Arun District Council
Planning Department
Maltravers Drive
Littlehampton
West Sussex
BN17 5LF

14th November
~~14th November~~ 2012

Re: Planning Application R/175/12 - No. 46 Seafield Road, Rustington, BN16 2JQ

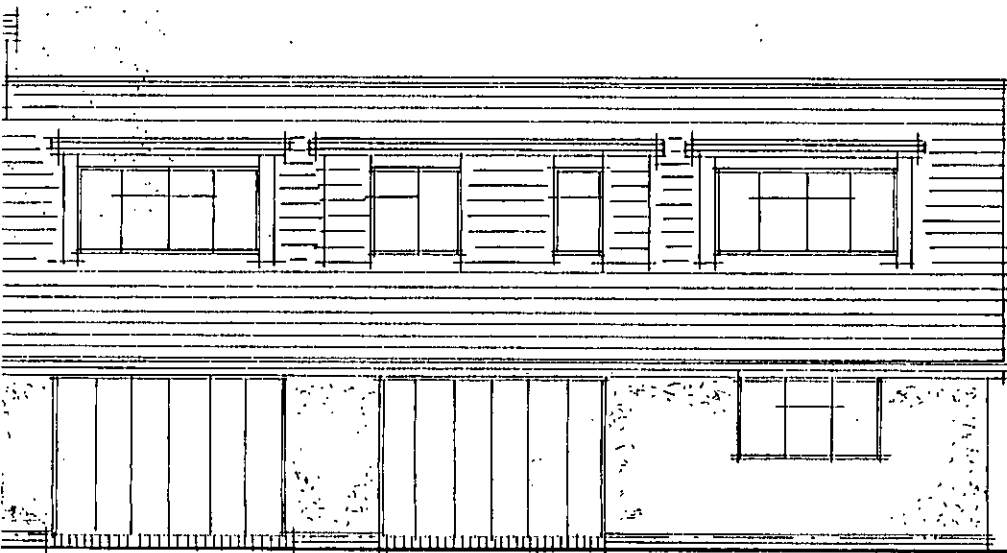
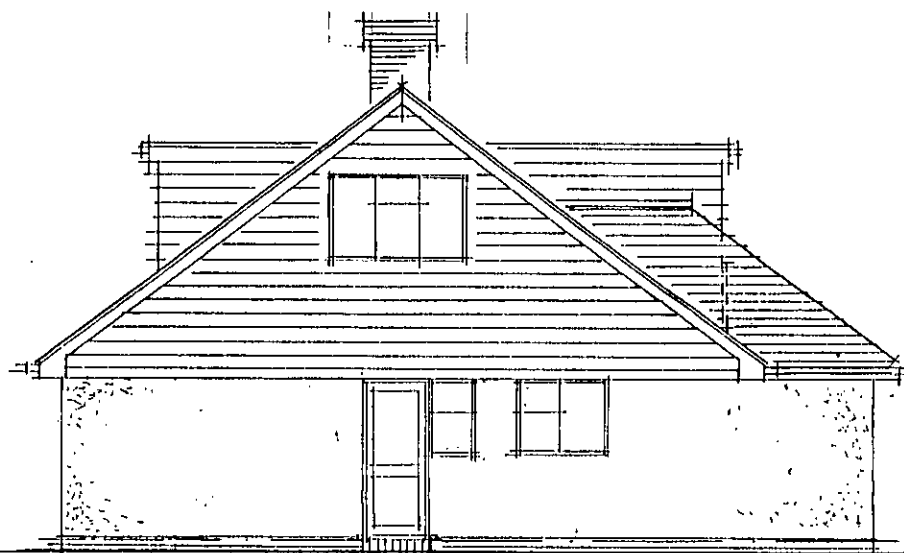
3. Apart from the positioning of the proposed dwelling on the site we are concerned that the ridge height of the proposed dwelling is 6.00M when compared with the existing dwelling height of 5.70M.

SCHEMATIC OF N° 46 TO BE DEMOLISHED 1/200

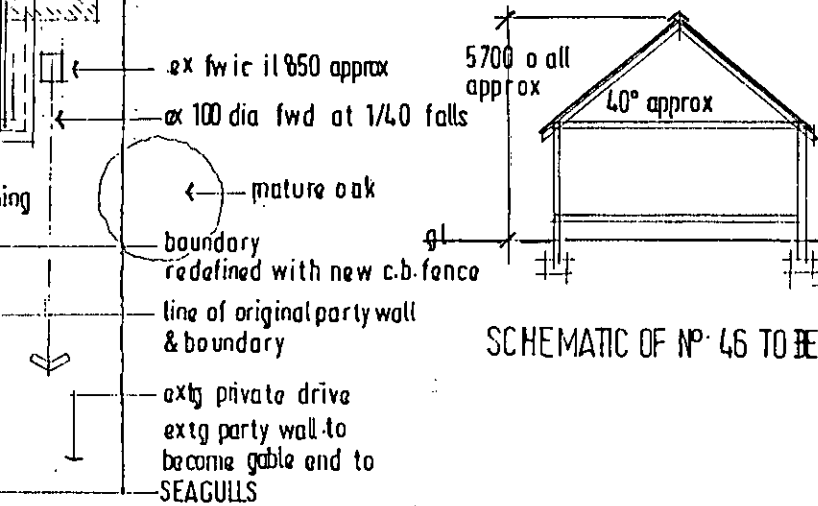
2. The drawing of the existing building cannot be correct in that it creates the impression that the existing four bedroom dwelling is being replaced with a new four bedroom dwelling. The drawing of the existing dwelling has no kitchen and so in fact it is at most a three bedroom dwelling. It is interesting to note that the GIA (Gross Internal Area) of the proposed dwelling is in excess of 2,050ft² compared to the existing dwelling which has a GIA of approximately 650ft². Interestingly the Ground Floor GIA comparison is 1190ft² for the proposed dwelling compared with 650ft² for the existing dwelling, a 68% increase in footprint. The overall increase in GIA for both floors of the proposed dwellings compared with the existing dwelling represents a 215% increase in area. Quite simply this demonstrates that the proposal is inappropriate and, as mentioned above, is an overdevelopment of the small site.

BLOCK PLAN 1/500

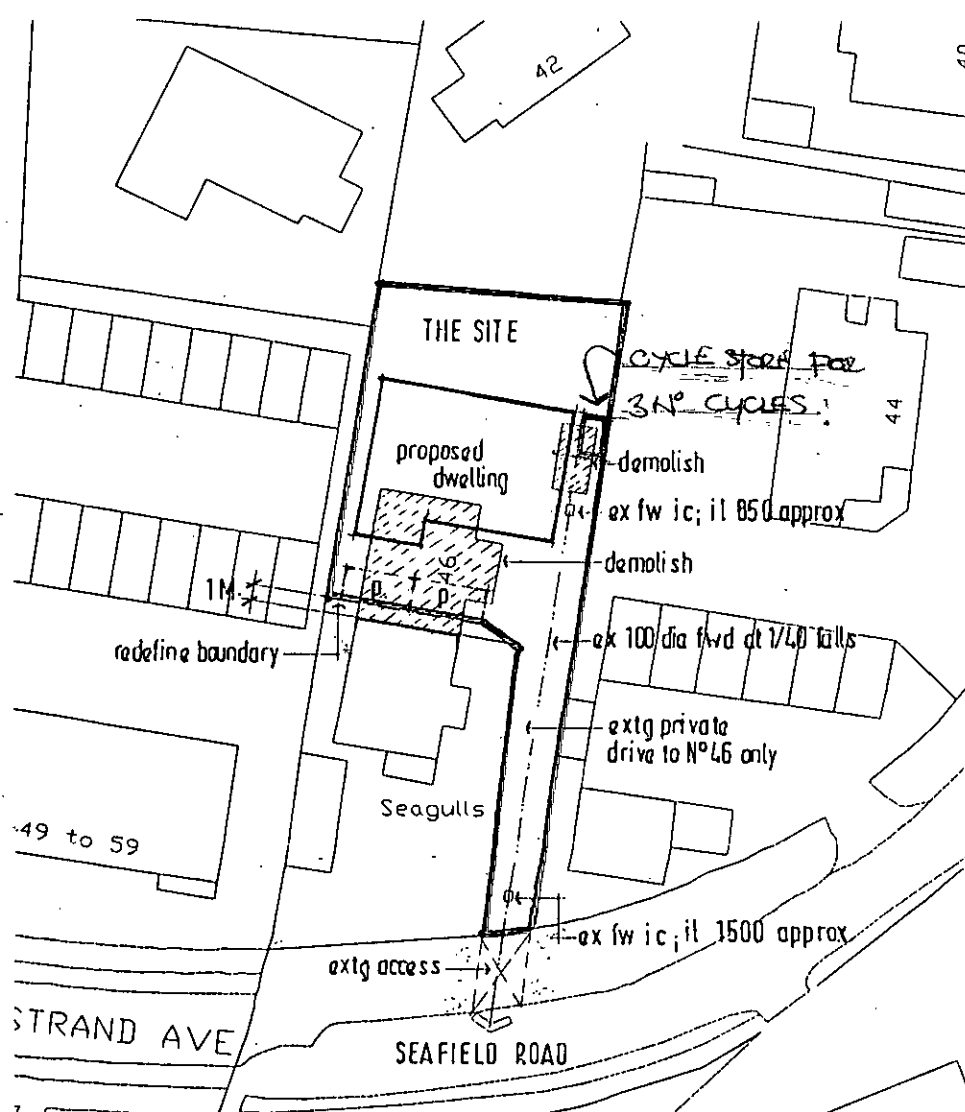
1. The development in our opinion is an overdevelopment of the current site in relation to the surrounding buildings. The existing building is a relatively semi-detached single storey retirement/ holiday bungalow whereas the proposed development is a large detached two storey family home which is built tight to the West and East boundaries and leaves little space to the front or rear (South and North) of the site. It is evident that the mass of the development is inappropriate when compared with the surrounding area.
